CITY OF ALBUQUERQUE

Site: Andalucia

Re: Drainage Ordinance (14-5-2-1) Violations for Erosion and Sediment Control

Erosion Sediment Control Plan

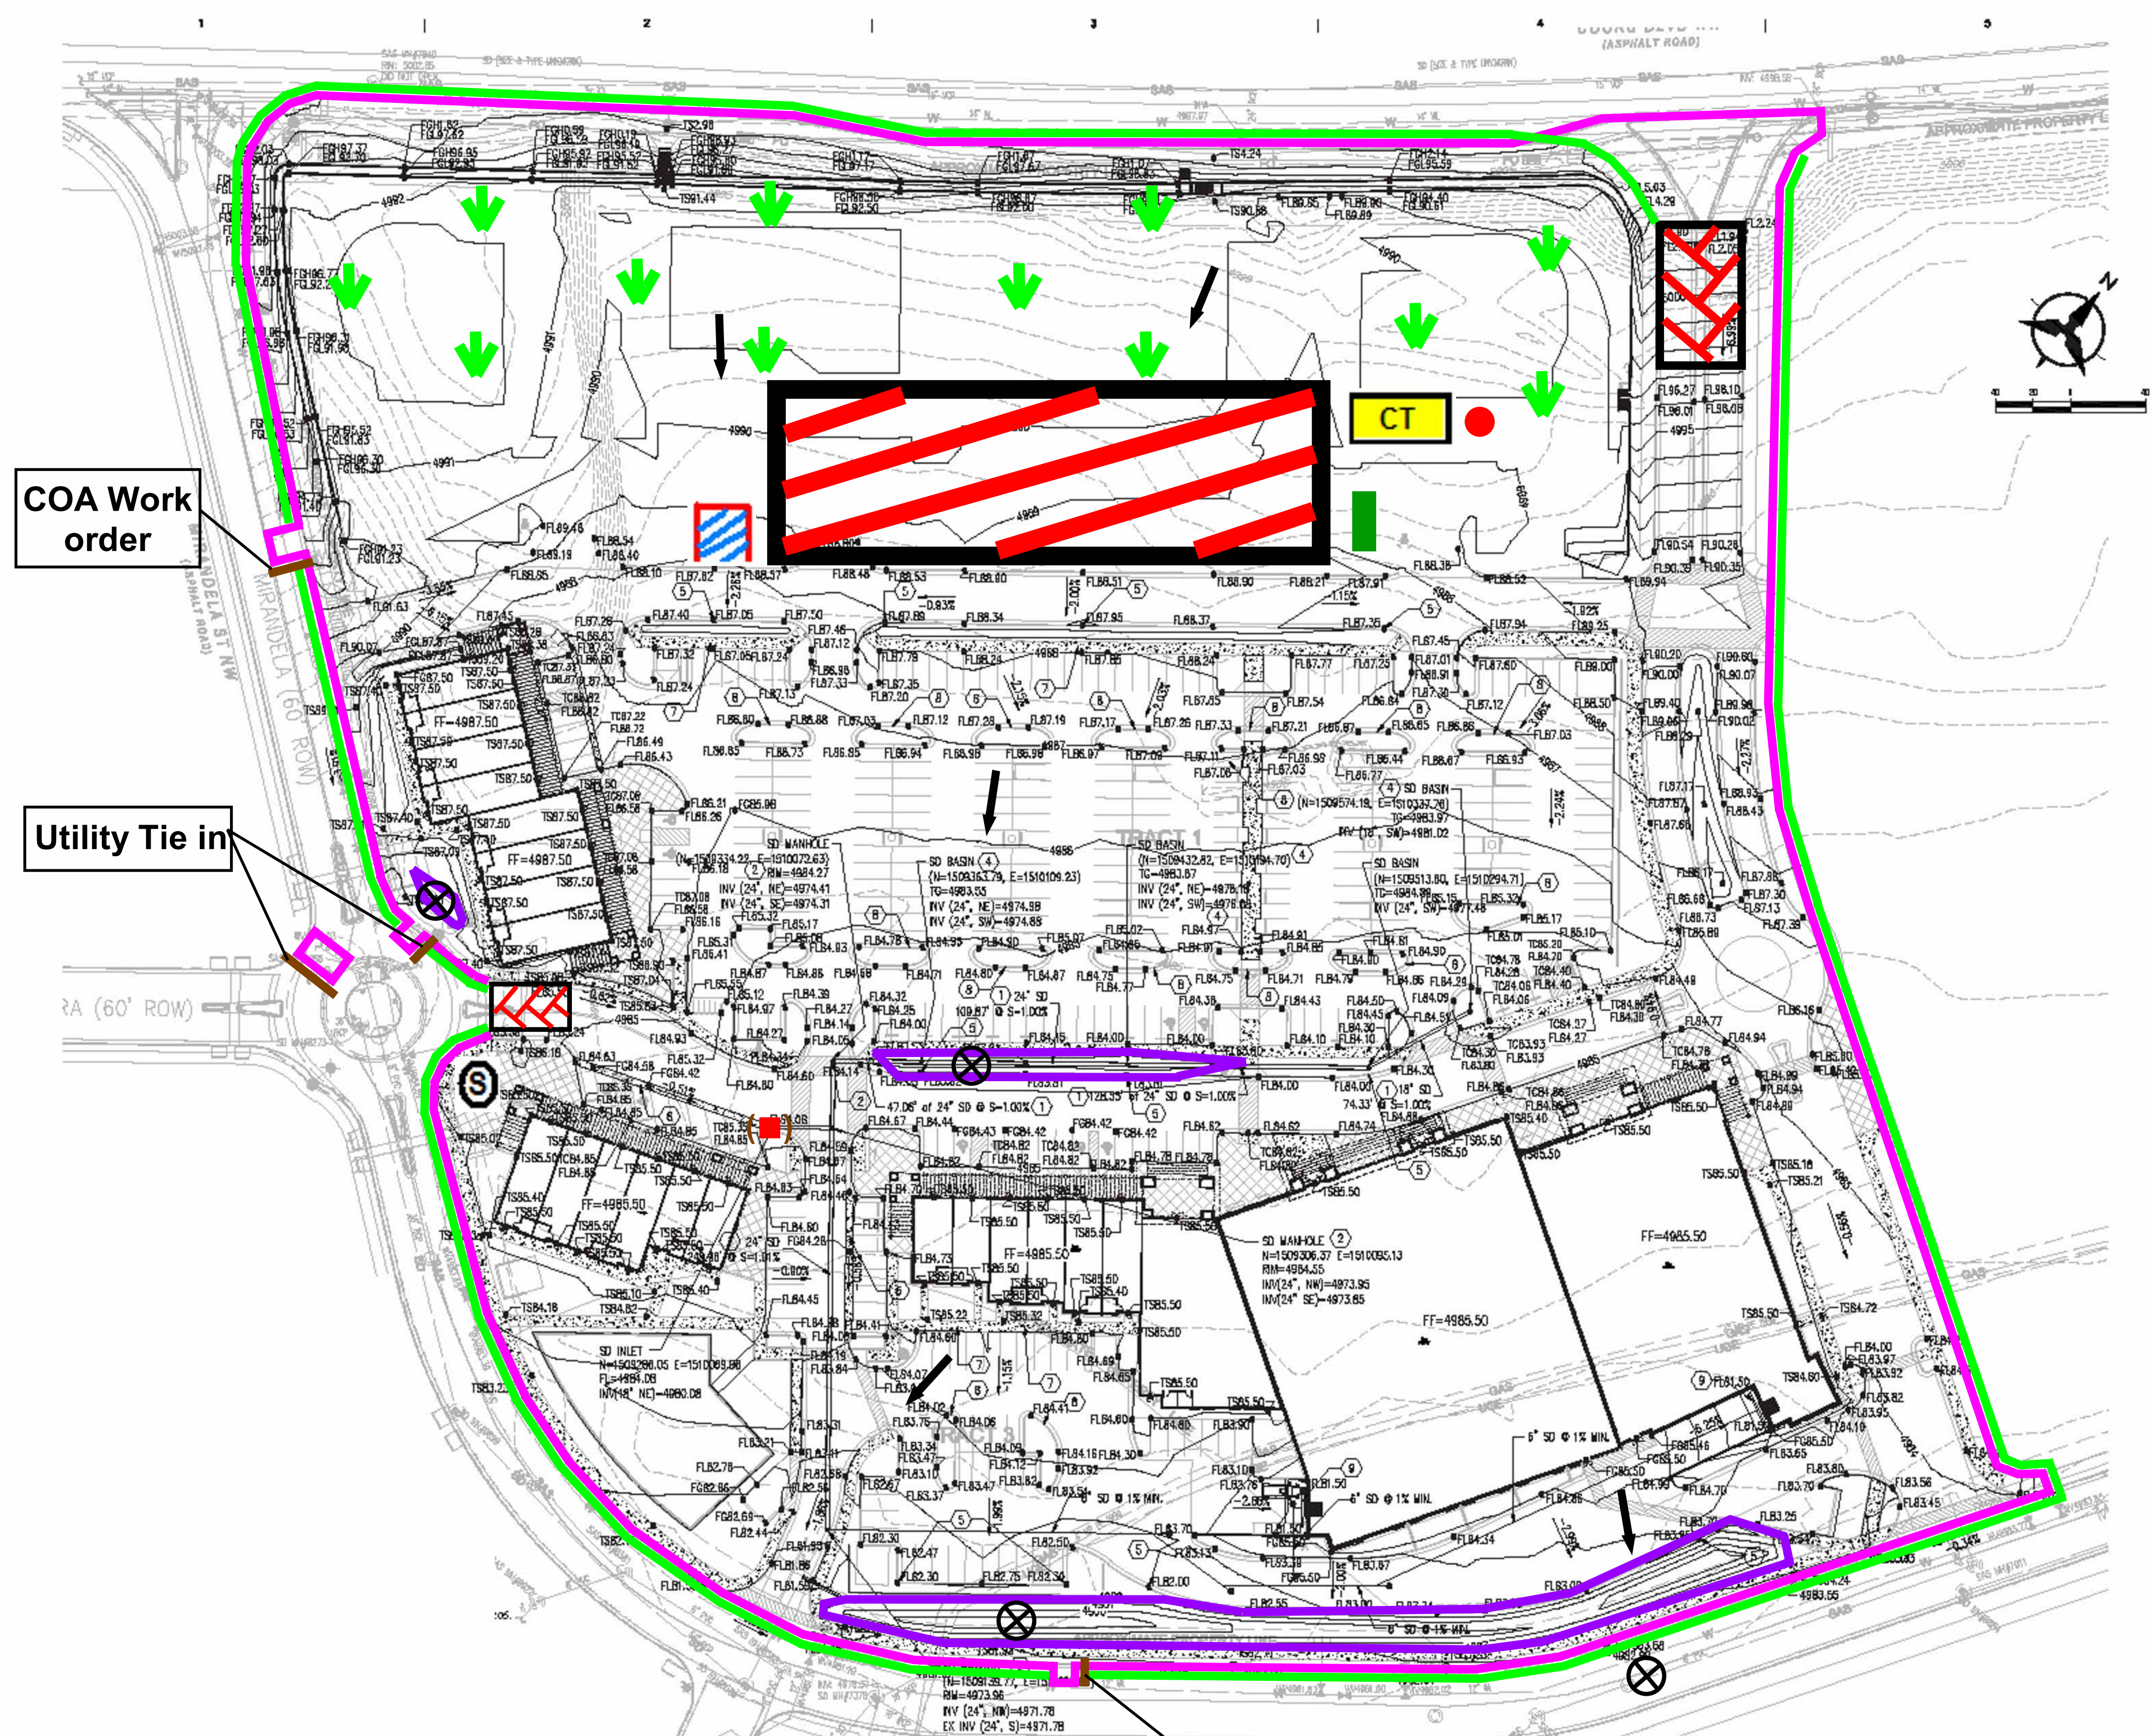
1. Dirt ramp in street.
2. No track-out pad/stabilized construction entrance.

Dirt ramp in street and no track-out pad.

1. Remove dirt ramp and associated dirt from street.
2. If you wish to continue to use this location to exit the site, a track-out pad/stabilized construction entrance is required.
